# Rezoning Transportation Analysis

Petition Number: 2022-216

Date	Description
05-24-2023	First Review (JP)
11-27-2023	Second Review (TP)
12-19-2023	Third Review (IW)
01-24-2024	Fourth Review (KC)
02-28-2024	Fifth Review (TM)

## Transportation Summary

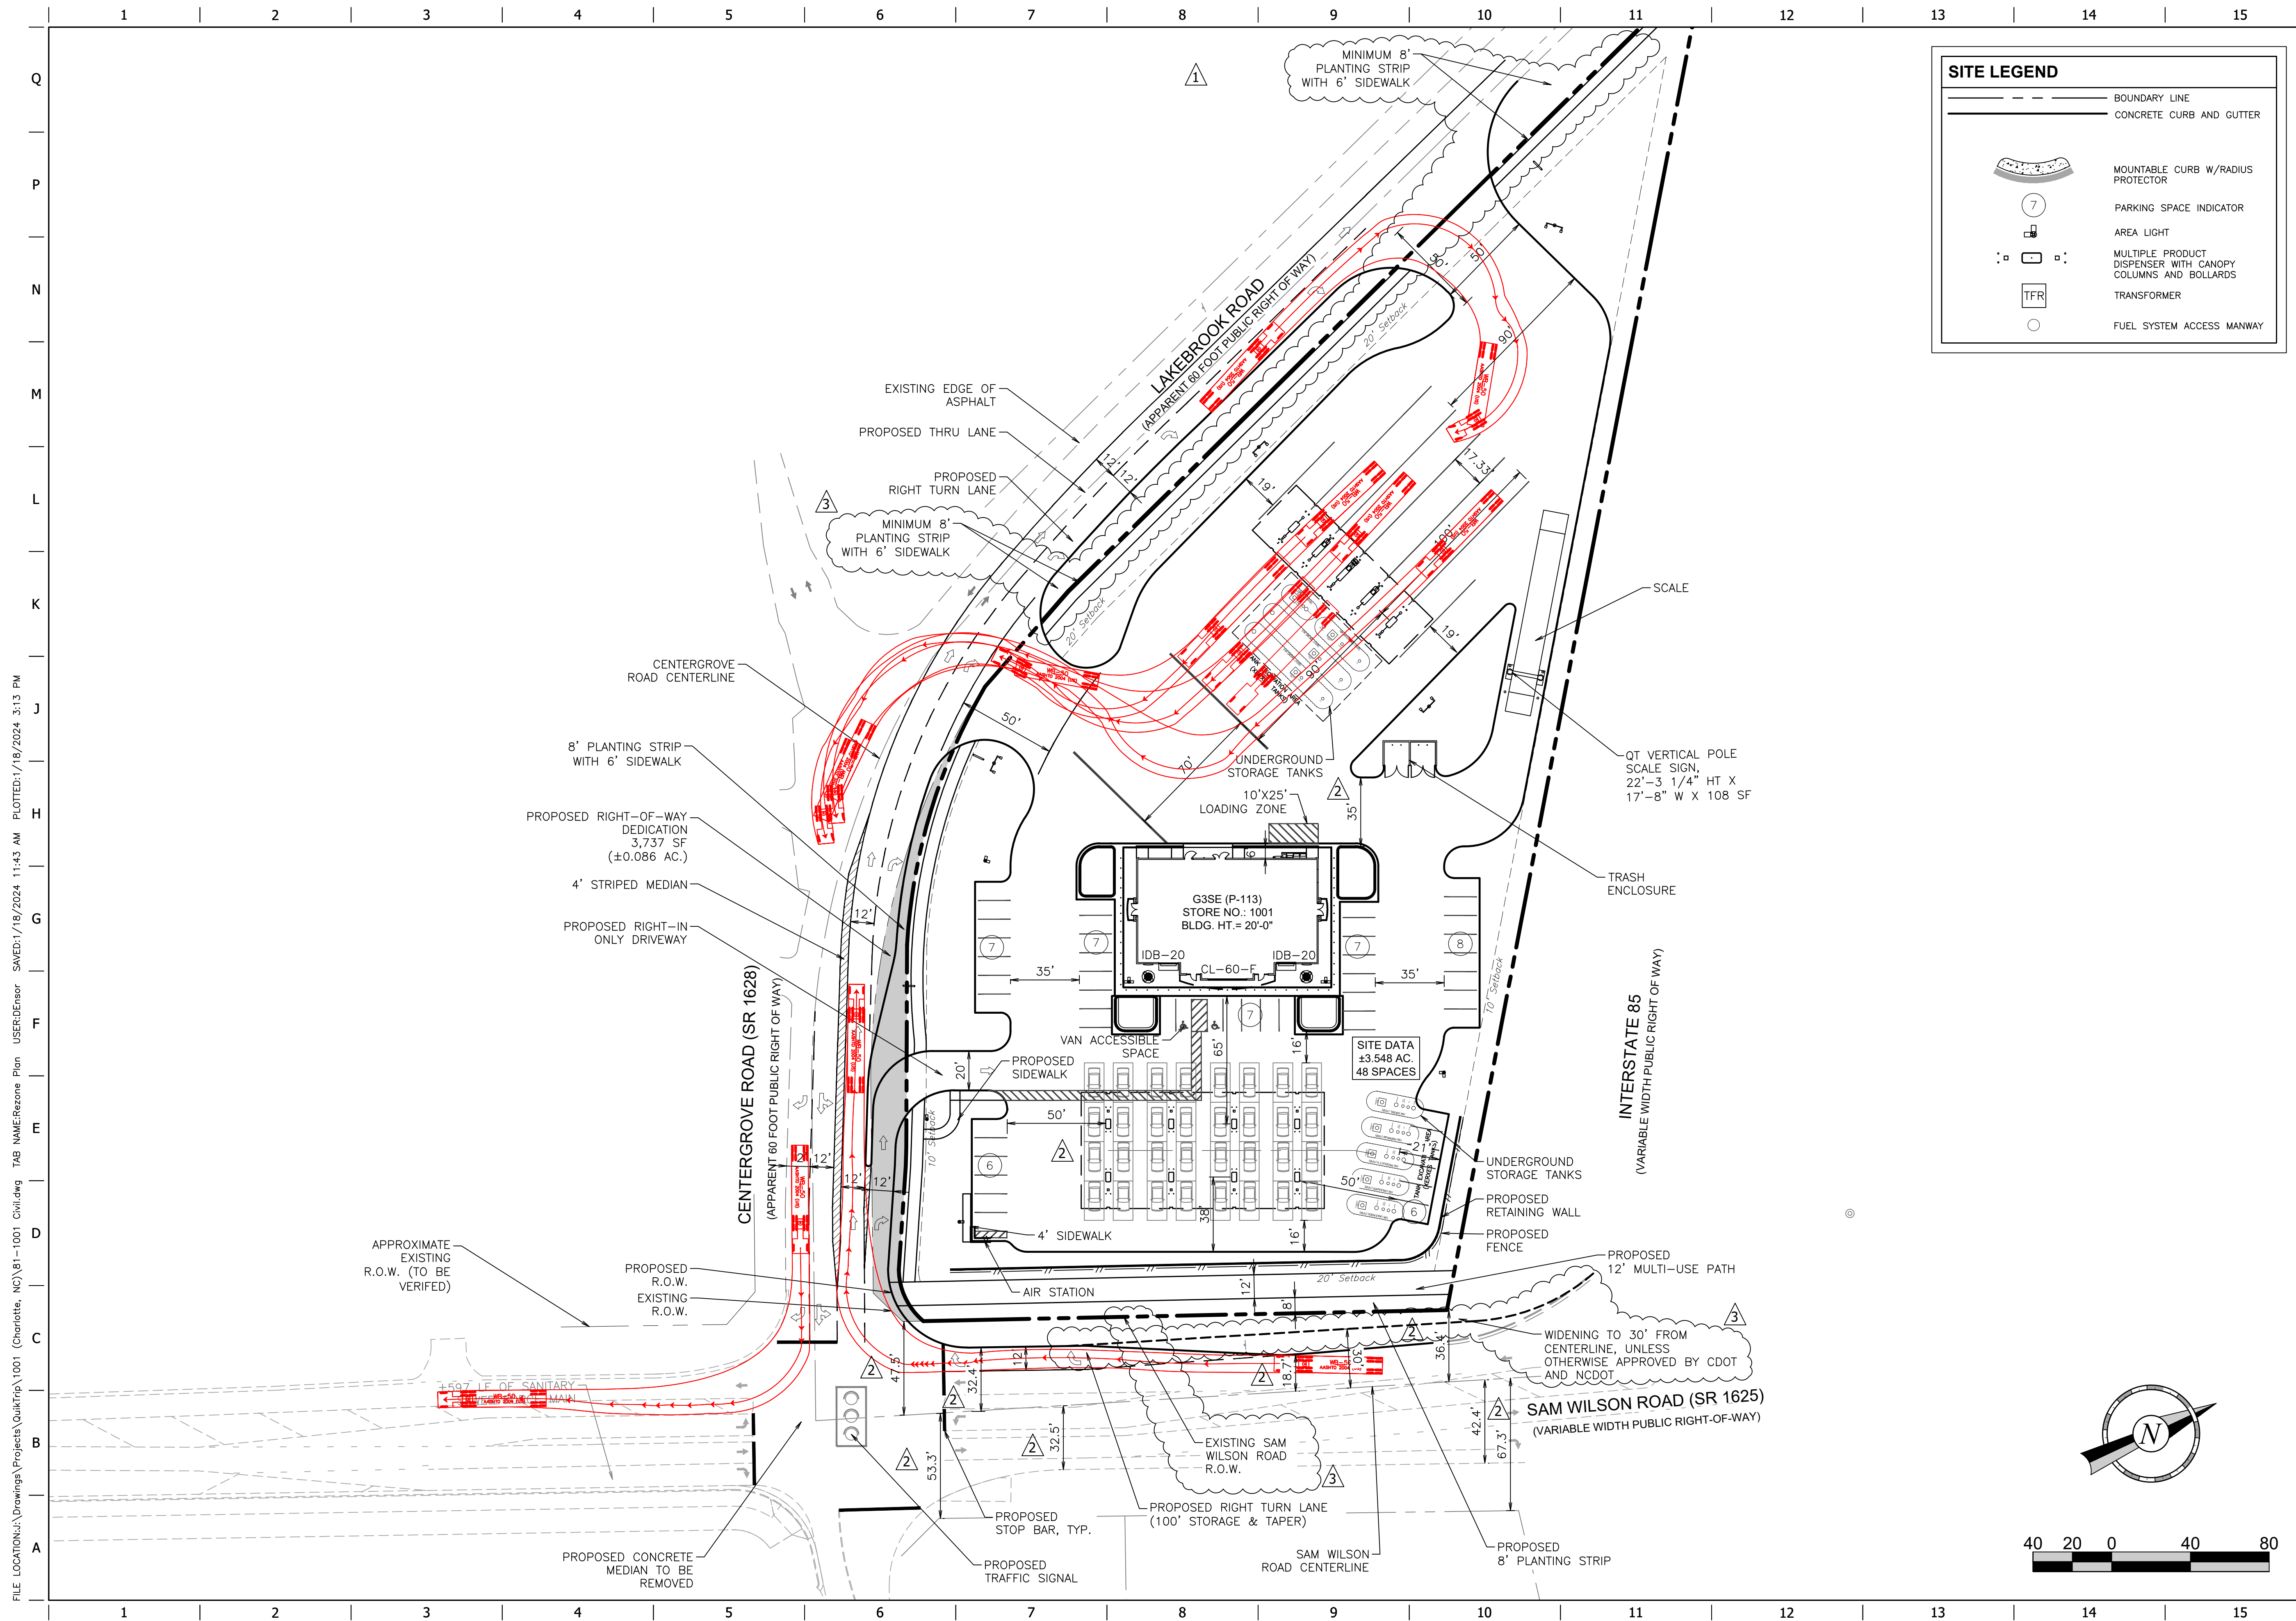
5. **New comment 01.24.2024:** Conflict with revised site plan and conditional notes, site plan shows 30' and conditional note states 35' please address.

6. **New Comment 12-20-2023:** Revise site plan to clearly show and label the location of existing right of way and proposed right of way.

**Clarifying Comment 01.24.2024:** Label and clearly dimension the existing right of way and the proposed right of way.

**Clarifying Comment 02-28-2024:** Label and Dimension ROW, curb and gutter (existing and proposed) along Centergrove Road and Lakebrook Road. Dimensions shall be from roadway centerline.

7. **New Comment 02-28-2024:** Driveway stem is measured from the ROW not the edge of travel. Revise dimension location and site plan.
